**Consultation Response from KC,
 Conservation & Design**
2026/91633 39, Spinkfield Road, Birkby, Huddersfield, HD2 2AY
Erection of front porch (within a Conservation Area)
Date Responded: 29 September 2026
Responding Officer: Amanda Chester
Responding Ref:

The application relates to the erection of a front porch at 39 Spinkfield Road, Birkby, Huddersfield. The property is located within the Birkby Conservation Area.

Front Elevation S
1 : 50

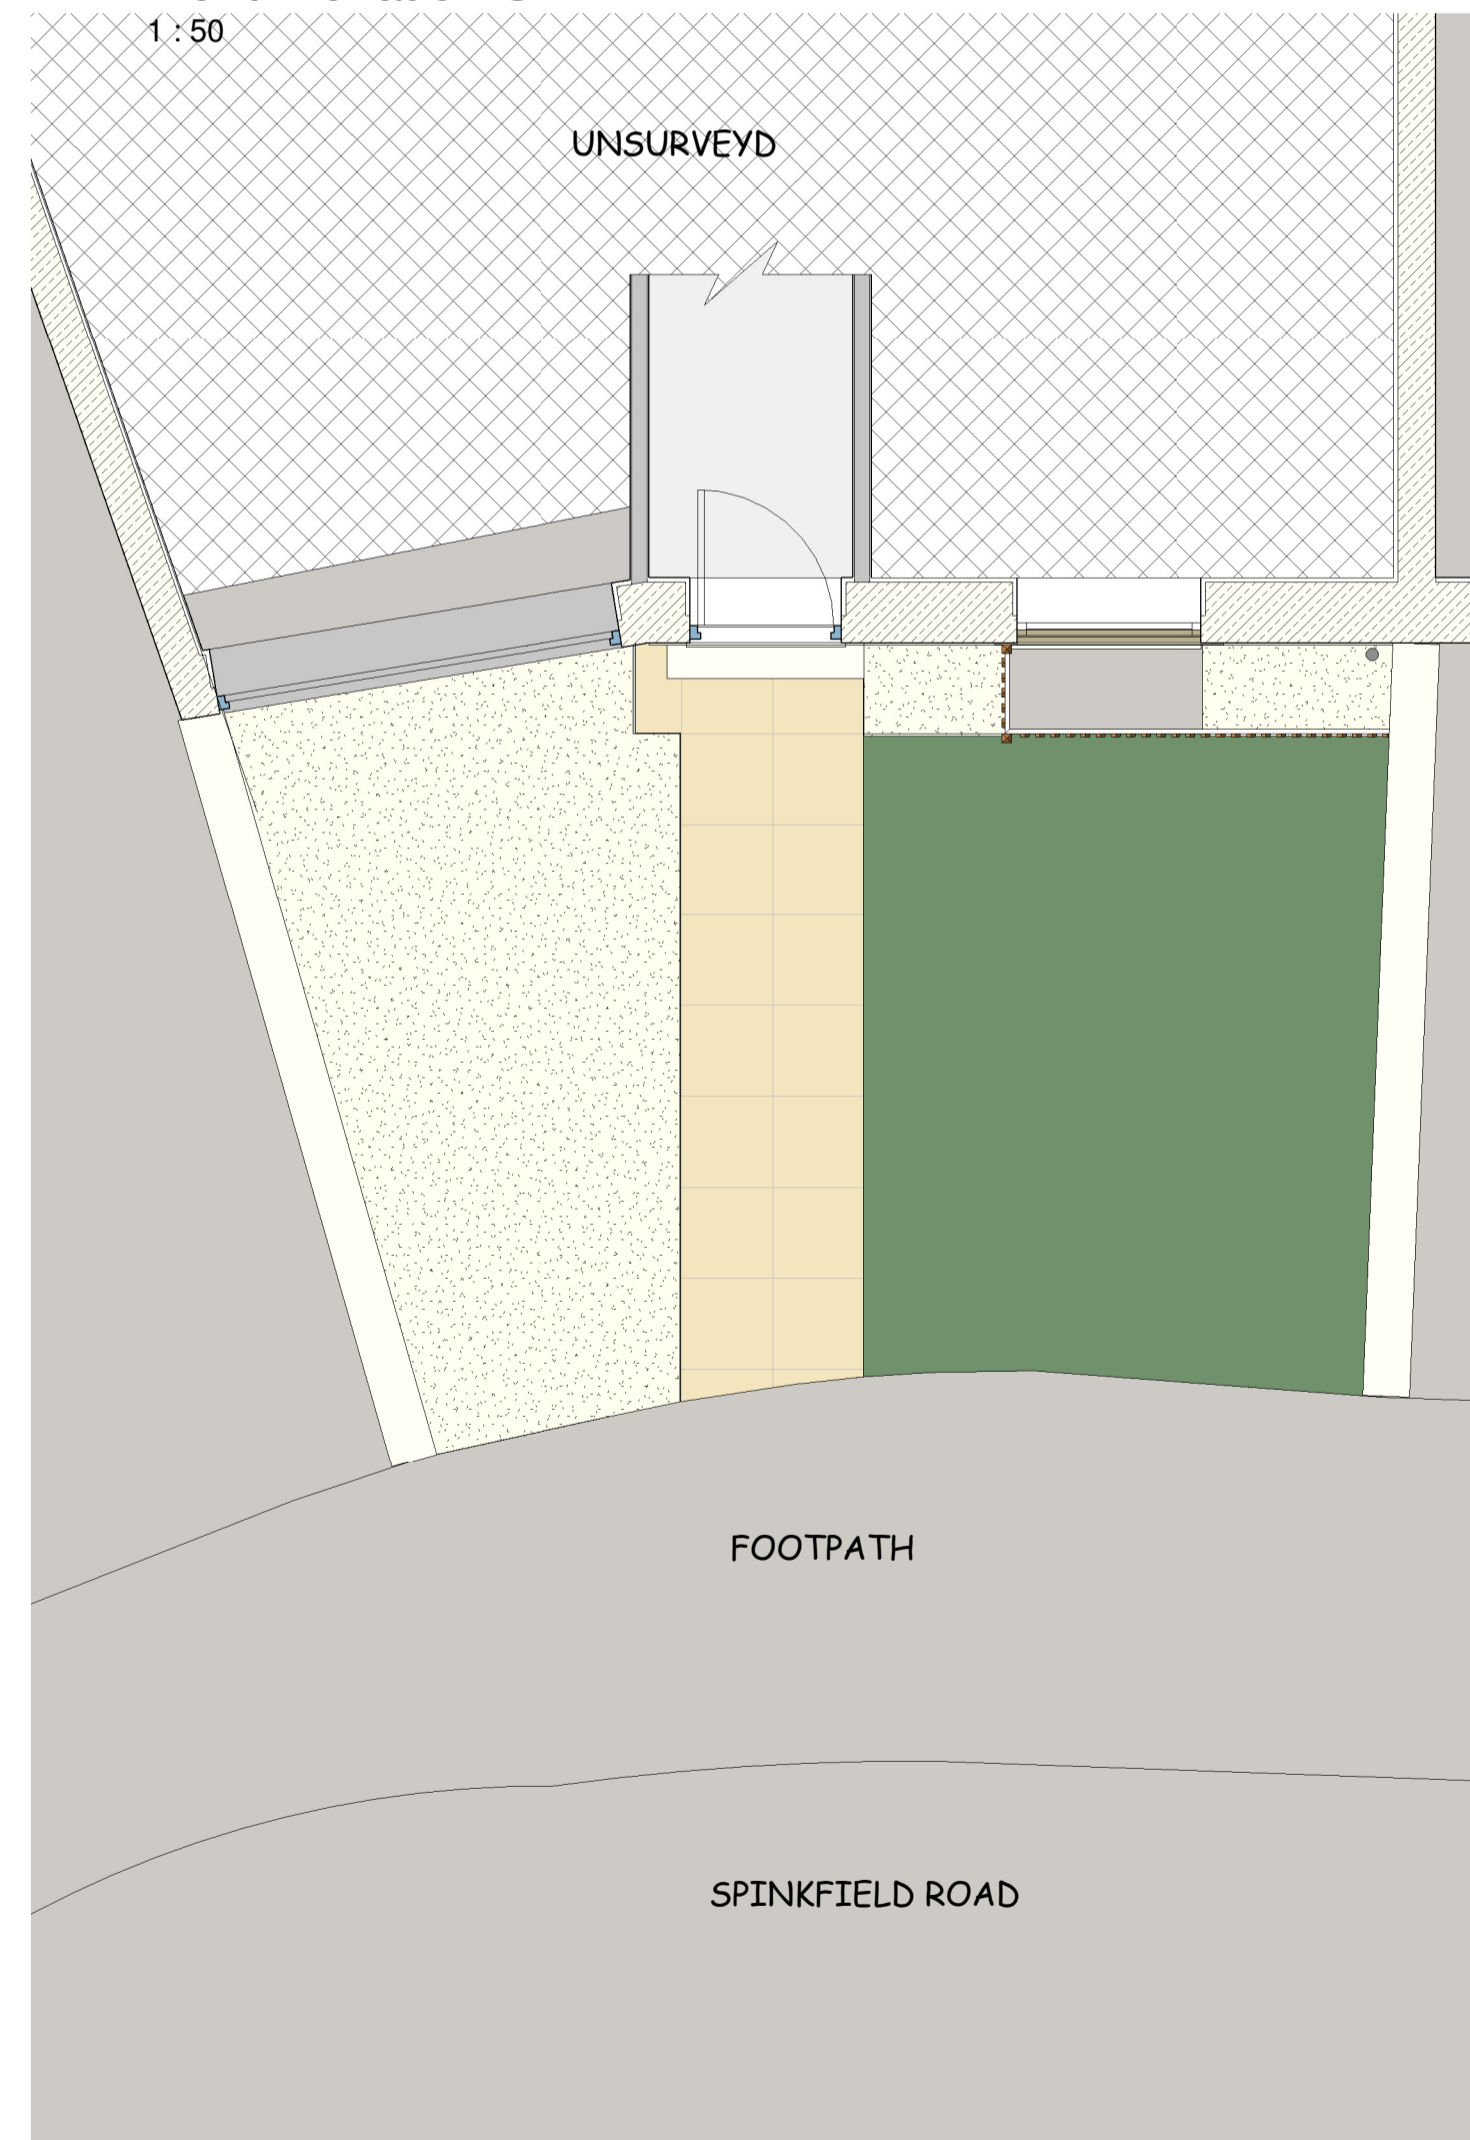
Conservation and Design object to the application on the grounds that the introduction of the porch will break up the regularity and uniform appearance of the terrace in which it sits, introducing visual clutter to the elevation. This would adversely affect the special character of the conservation area and result in a low level of harm to its significance without providing any tangible public benefits which would outweigh that harm. The proposals are therefore in contravention of Section 72 of the Planning (Listed Buildings & Conservation Areas) Act (1990), Policies HE6 and HE9 of the National Planning Policy Framework and Policy LP35 of the Kirklees Local Plan.
